BOCA® NATIONAL BUILDING CODE/1999 PLAN REVIEW RECORD

Valuation: \$3,830,408 Plan Review # 040612
 Fee: 34,525.00 Date: 6/22/04

JURISDICTION: FORT LAUDERDALE
 BUILDING LOCATION: 191 RIVERSIDE ST.

BUILDING DESCRIPTION: AUTO DEALERSHIP
 OFFICES/REPAIR FACILITY/STORAGE

STAIR TOWER (289)

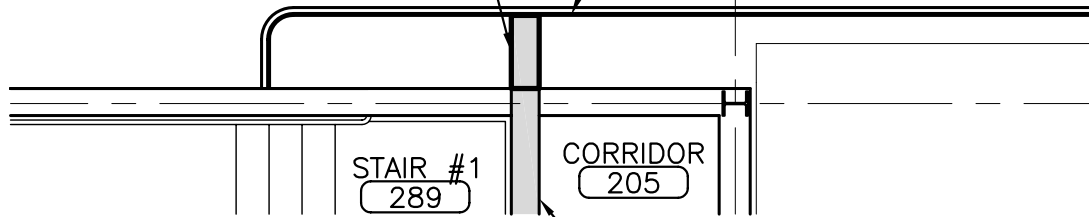
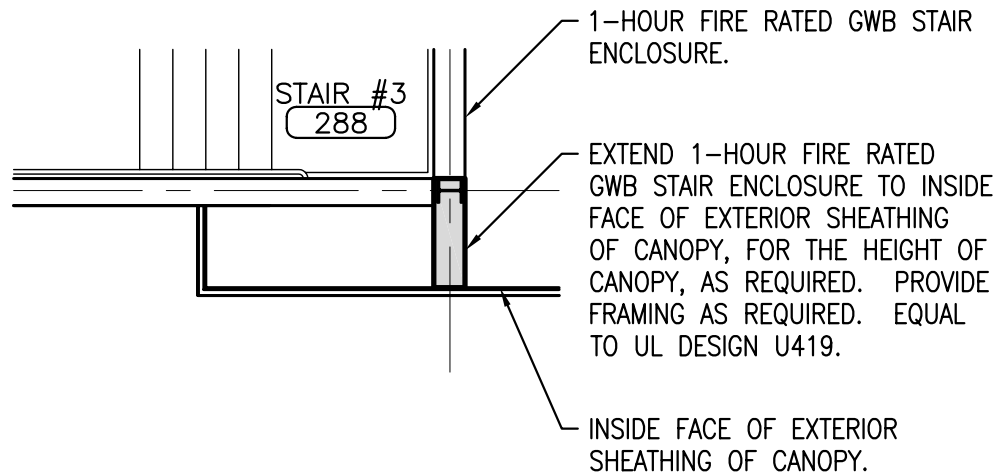
No	DESCRIPTION	Code Section
1	1-17 & 114	
	M1 20' x 20' SR 2200 CFM	
	ACME XTW 24 (NO FD)	
	NO FD SHOWN ON HVAC SUPPLY	
	NO FD ON EF-3	
	M2 NO FD SHOWN ON HVAC 4	
	SUP/RET.	
	ANO ON 20' x 20' SF	
	M3 HVAC 12' x 3' SUP	
	STAIR 3 DUCT PENETRATION	
	M4 - STAIR WAY 1 PENETRATION
